Our Ref: EN070007

Planning Act 2008 (as amended) – Section 51

Application by Liverpool Bay CCS Limited for an Order Granting Development Consent for the HyNet Carbon Dioxide Pipeline

Advice following issue of decision to accept the application for examination

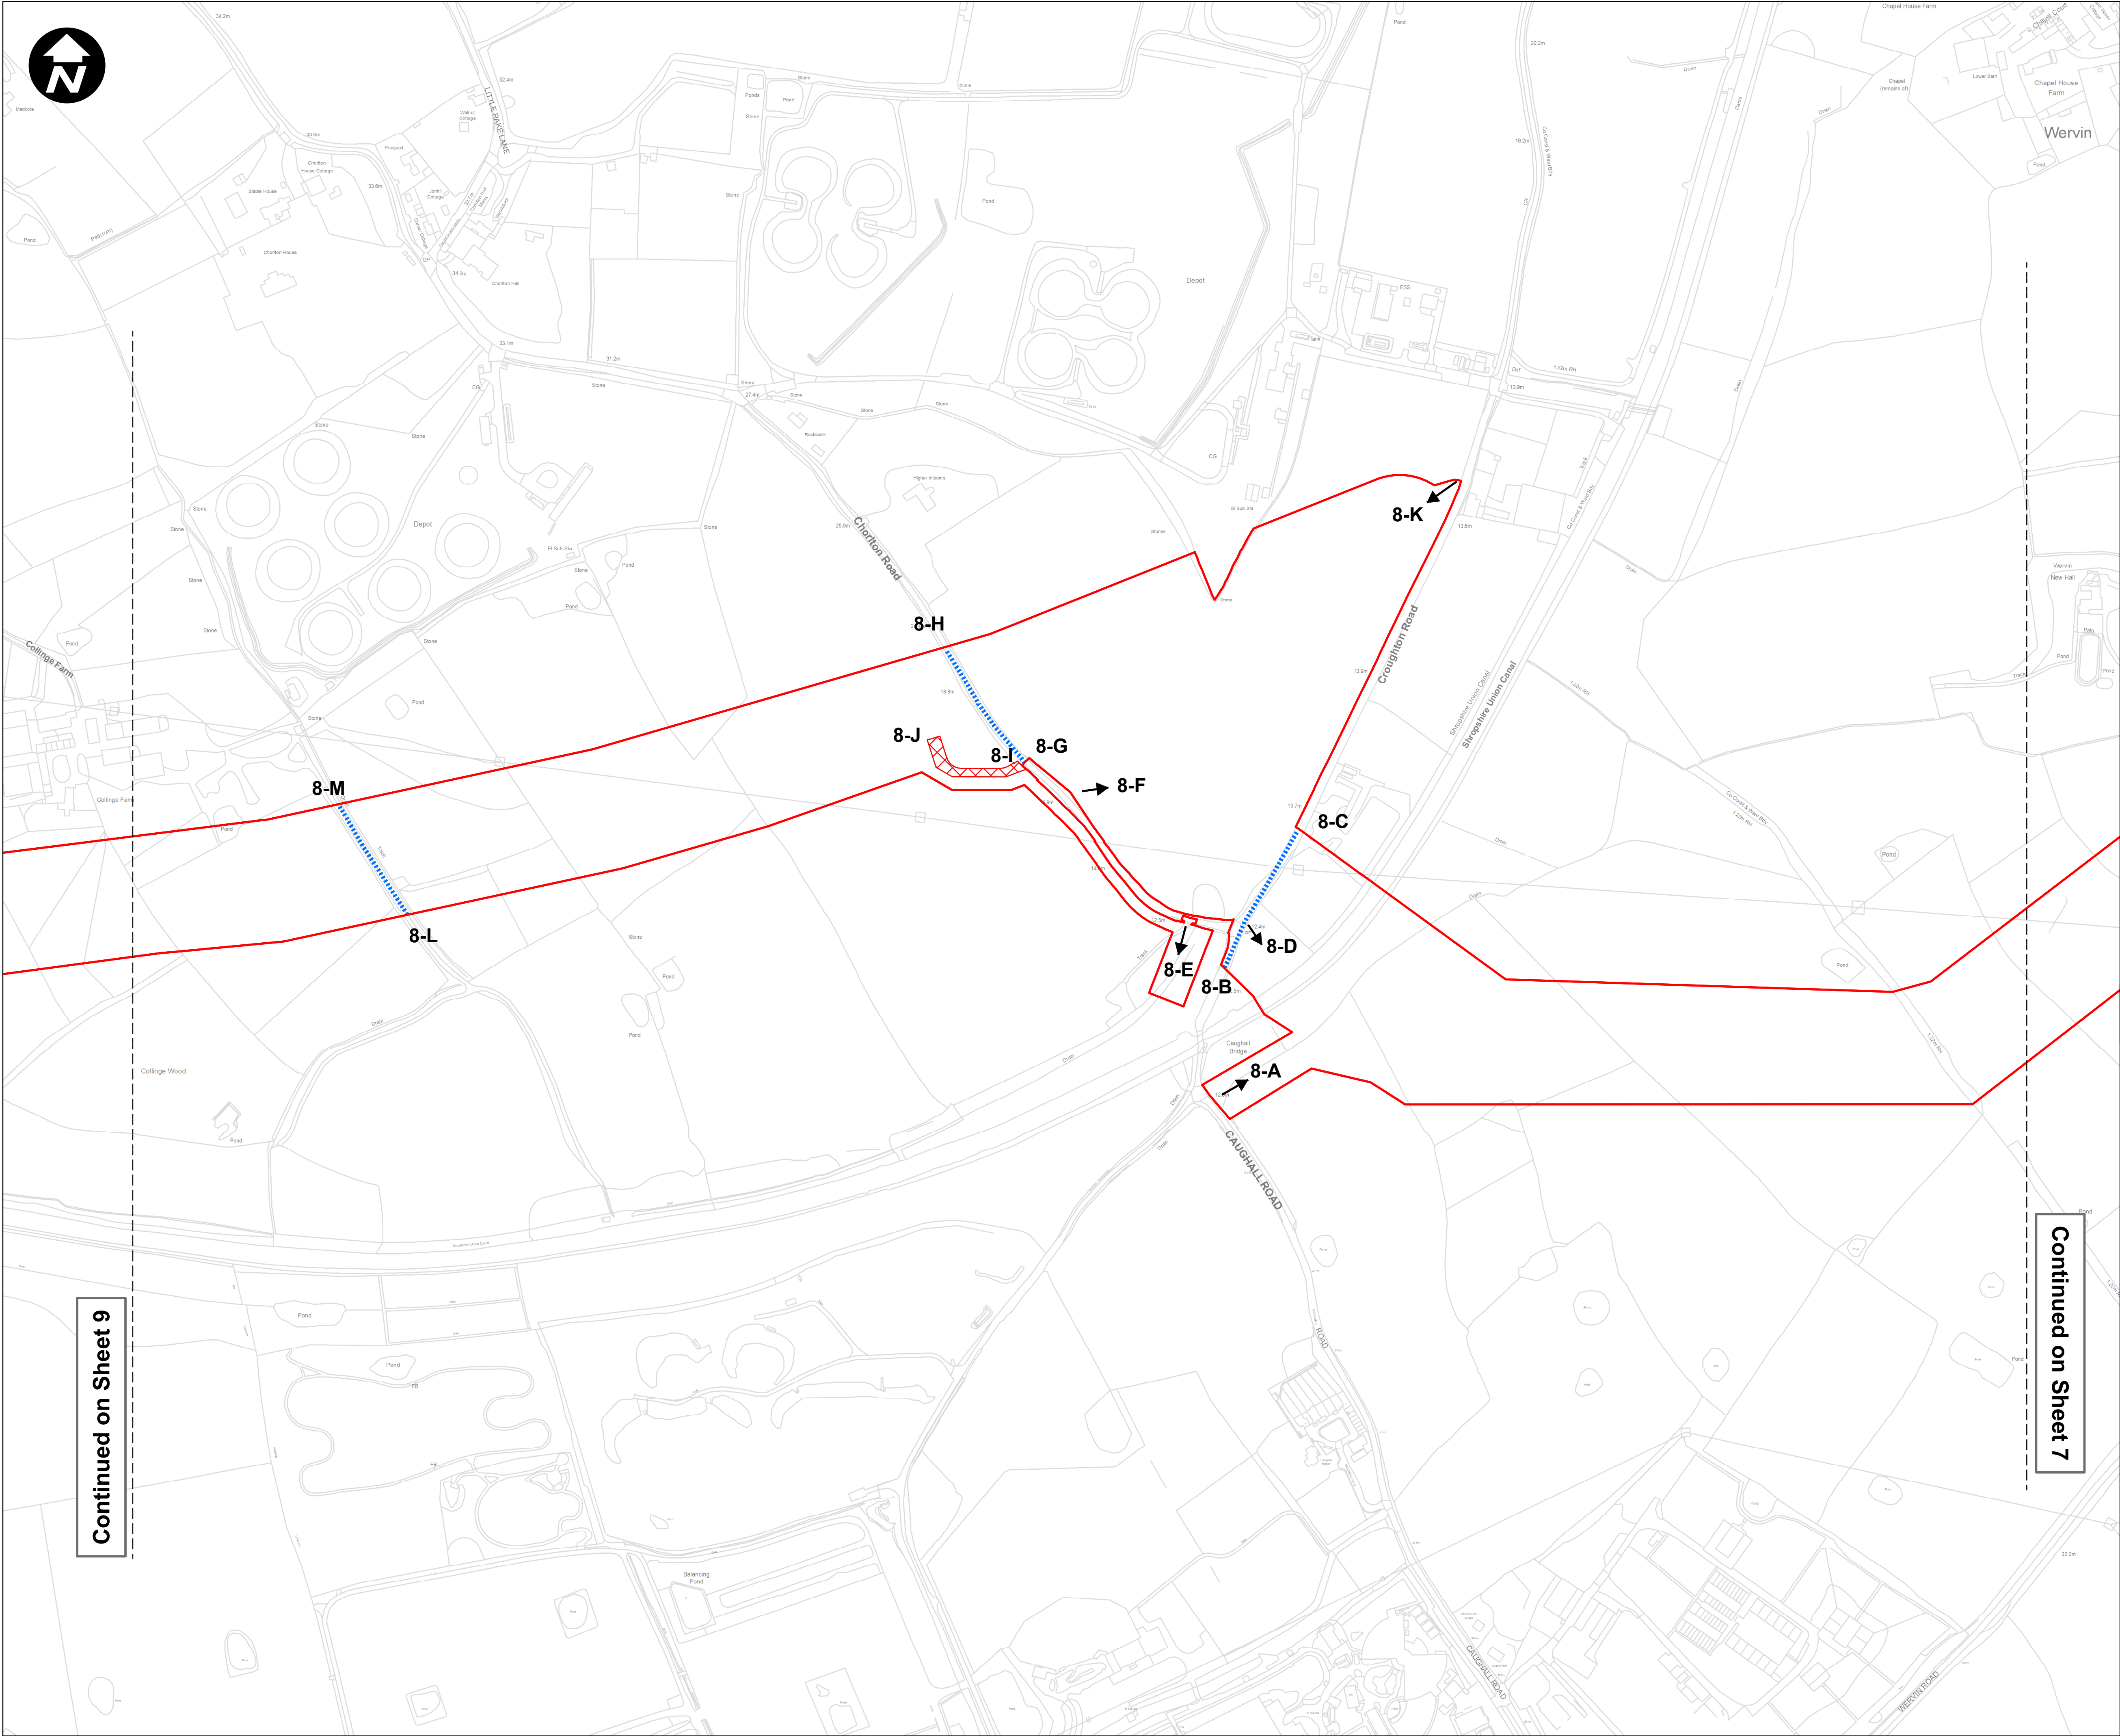
The Inspectorate notes that there are some discrepancies between the draft Development Consent order and the Access and Rights of Way Plans (see Ledger on sheet 8 and footpath 308/1 on sheet 15 of the Access and Rights of Way Plan).

The Applicant is advised to carry out a comprehensive review of the plans against the draft Development Consent Order.
